RE: GEOTECHNICAL THIRD-PARTY REVIEW, 5637 E. MERCER WAY, CITY OF MERCER ISLAND PROJECT NO. CAO15-001

This letter summarizes our review of Geo Group Northwest, Inc. (GGNW) responses to comments we made in our third-party geotechnical review letter dated July 12, 2019.

A PORTION OF GOVERNMENT LOT 3, OF SECTION 19, TOWNSHIP 24 NORTH, RANGE 5 EAST, W.M., KING COUNTY, WASHINGTON

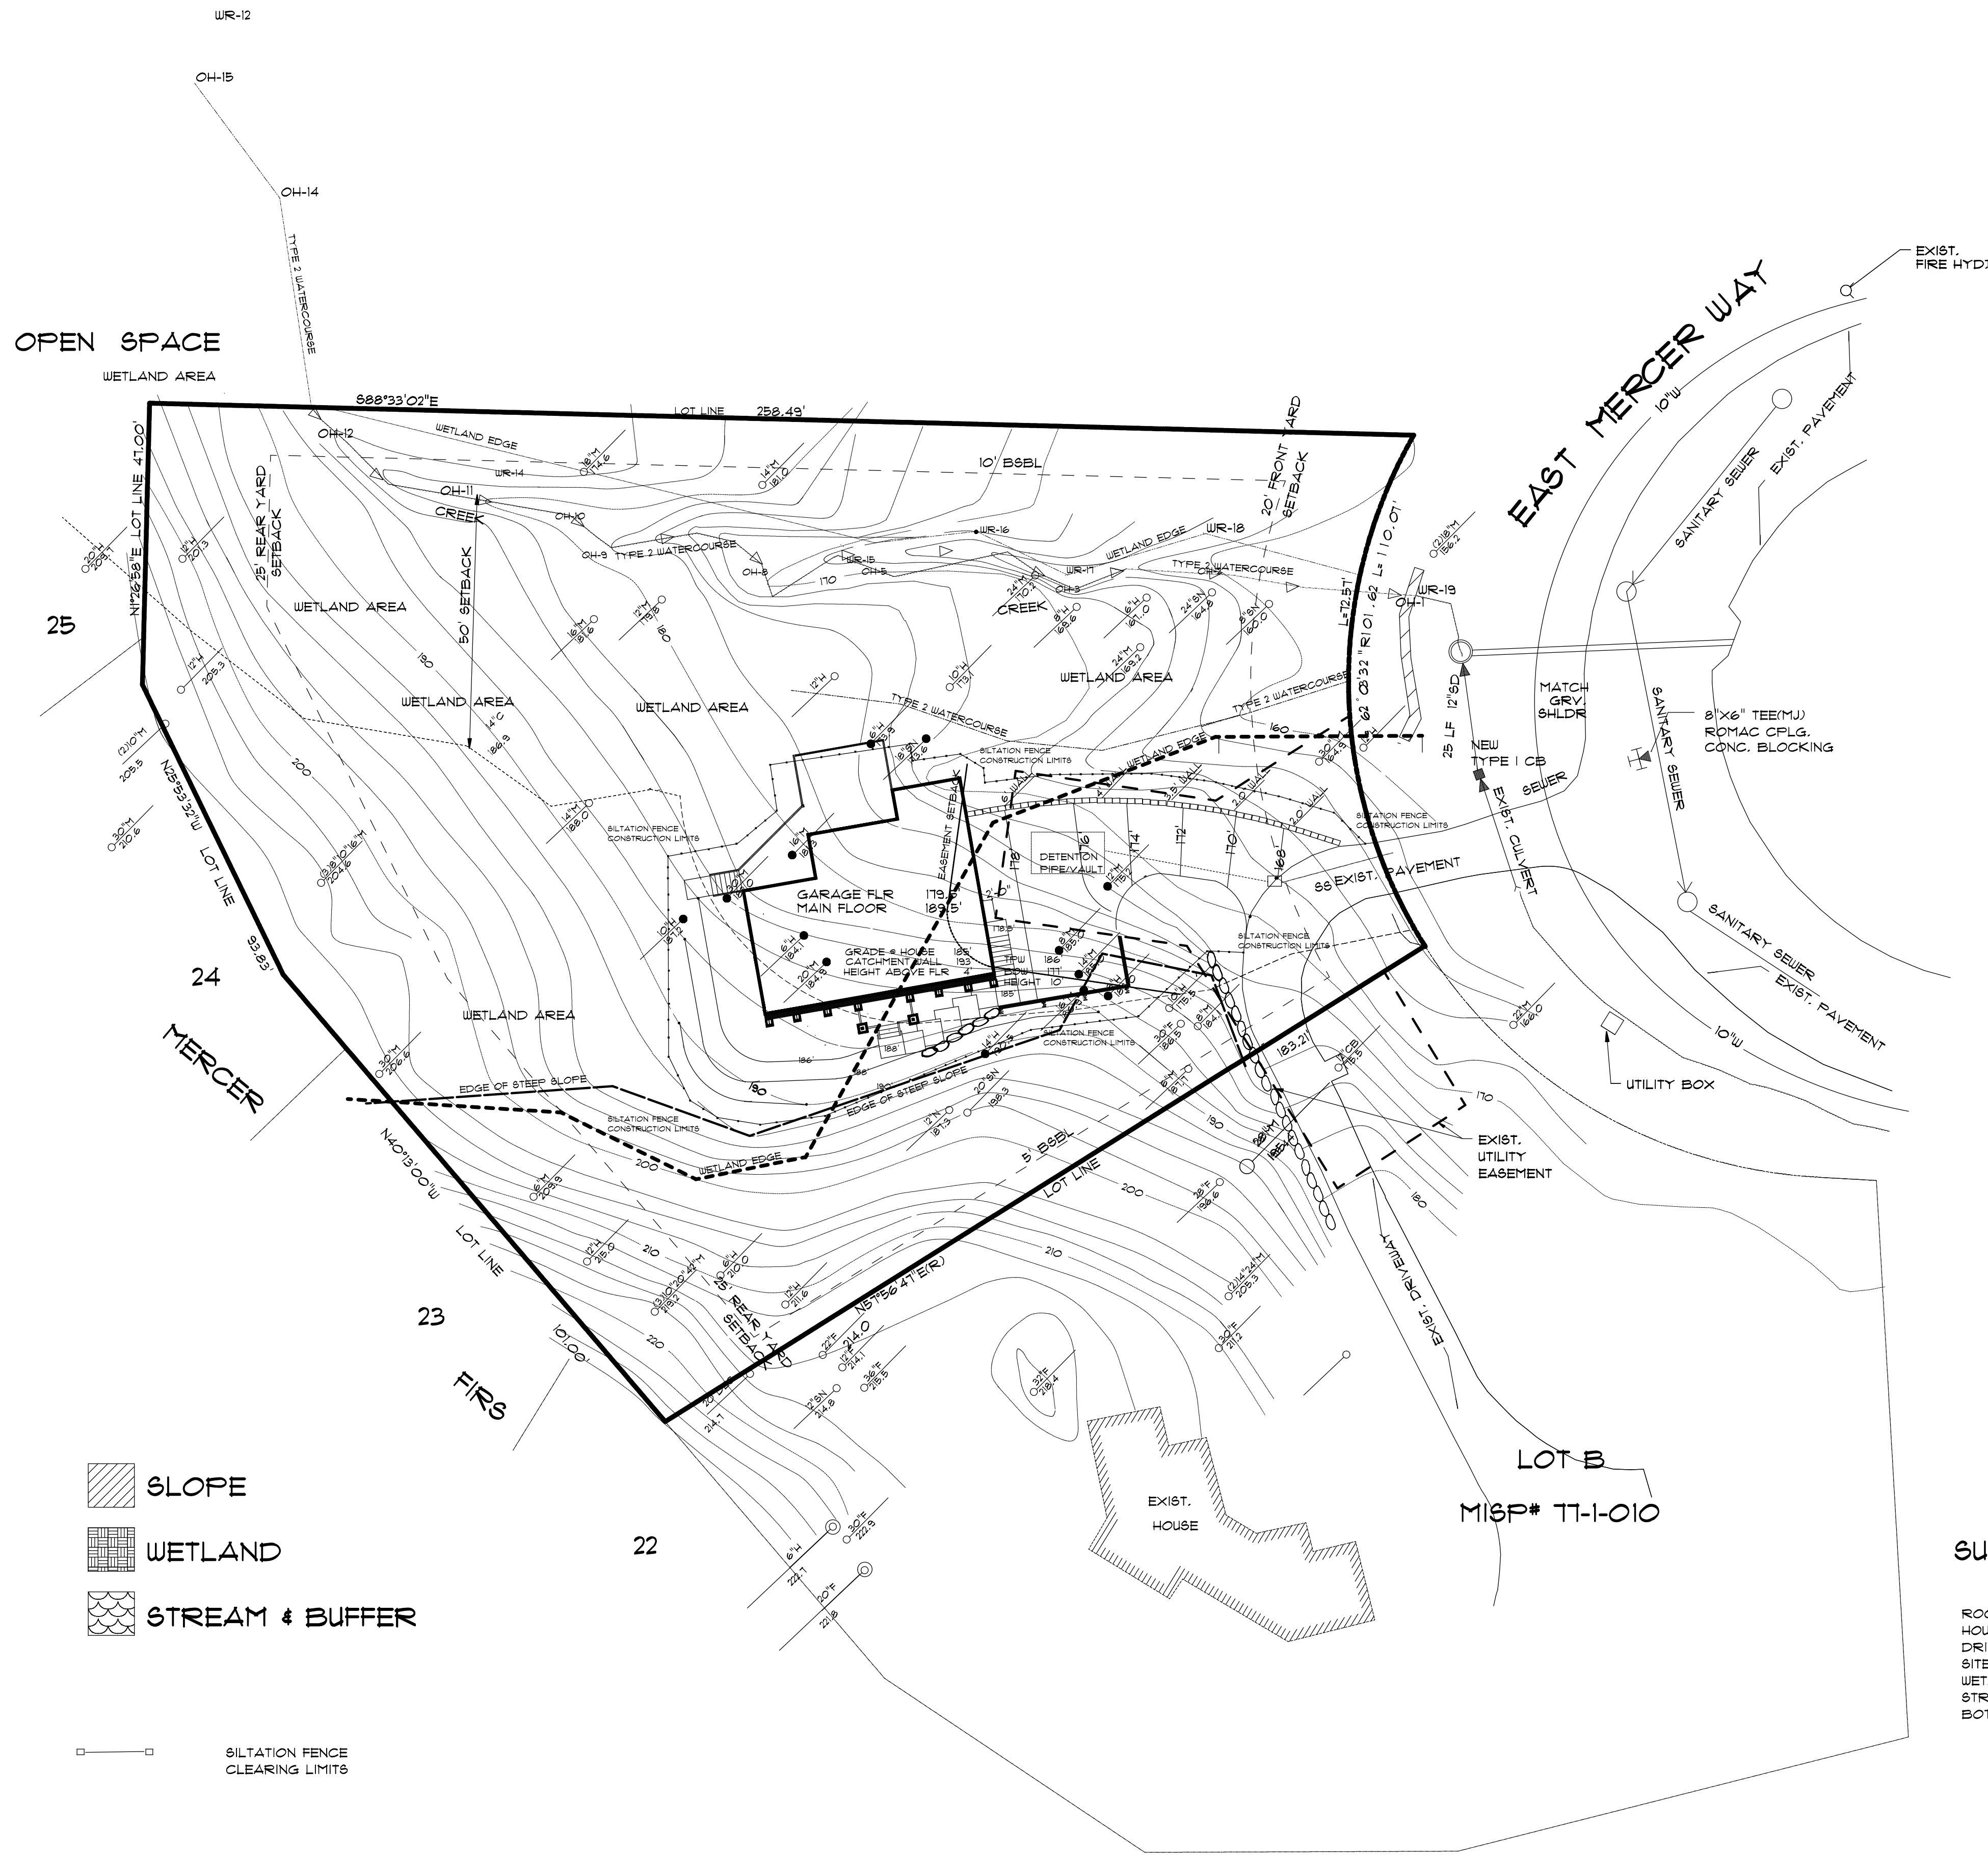
2. GGNW provided and updated site plan dated October 23, 2019. No further response needed.
3. GGNW states that all previous opinions, conclusions, and recommendations remain the same. No further response required.
